City of Portland, Maine - Building or Use Permit Application
 389 Congress Street, 04101 Tel: (207) 874-8703, Fax: (207) 874-8716

Permit No: 09-0311	Issue Date:	CBL: 111 A006001
------------------------------	--------------------	----------------------------

Past Use: Single Family Home	Proposed Use: Single Family Home - remove old garage Build new 20' x20' Garage w/ foundation	Permit Fee: \$80.00	Cost of Work: \$6,000.00	CEO District: 1
Proposed Project Description: remove old garage Build new 20' x20' Garage w/ foundation		FIRE DEPT: <input type="checkbox"/> Approved <input type="checkbox"/> Denied	INSPECTION: Use Group: Type	
		Signature:	Signature:	
PEDESTRIAN ACTIVITIES DISTRICT (P.A.D.)				
Action <input type="checkbox"/> Approved <input type="checkbox"/> Approved w/Condition <input type="checkbox"/> Denied				
		Signature:	Date:

Dept: Zoning **Status:** Approved with Conditions **Reviewer:** Tammy Munson **Approval Date:** 05/15/2009
Note: **Ok to Issue:**

LOT # 57 ON
BOULEVARD PARK
PLAN.

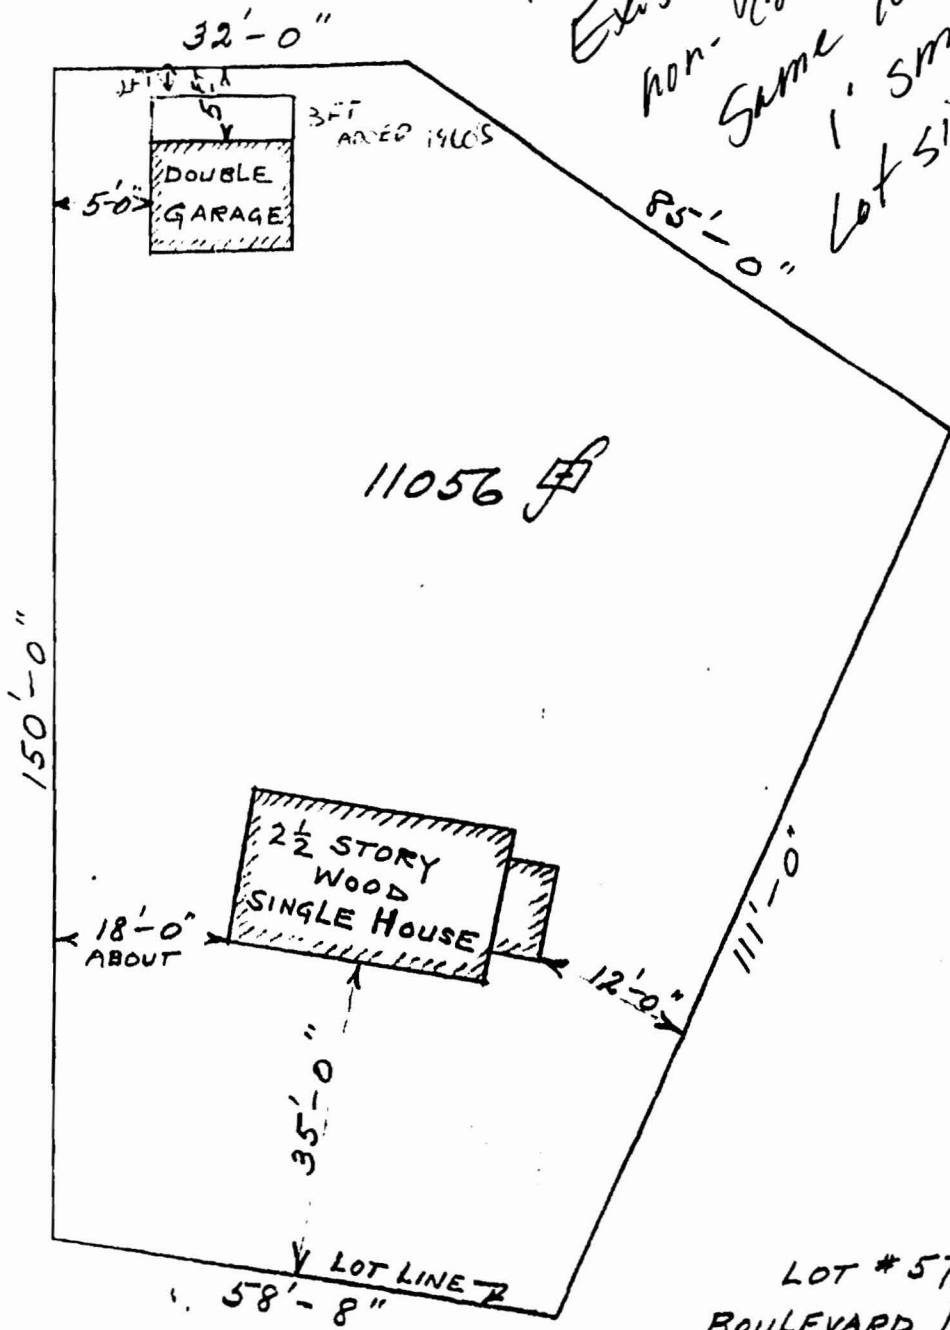
4/22/2009-tmm: left message for owner - cannot build proposed garage - current garage is non-conforming and it is proposed to build it closer and larger to the rear and side lines /tmm
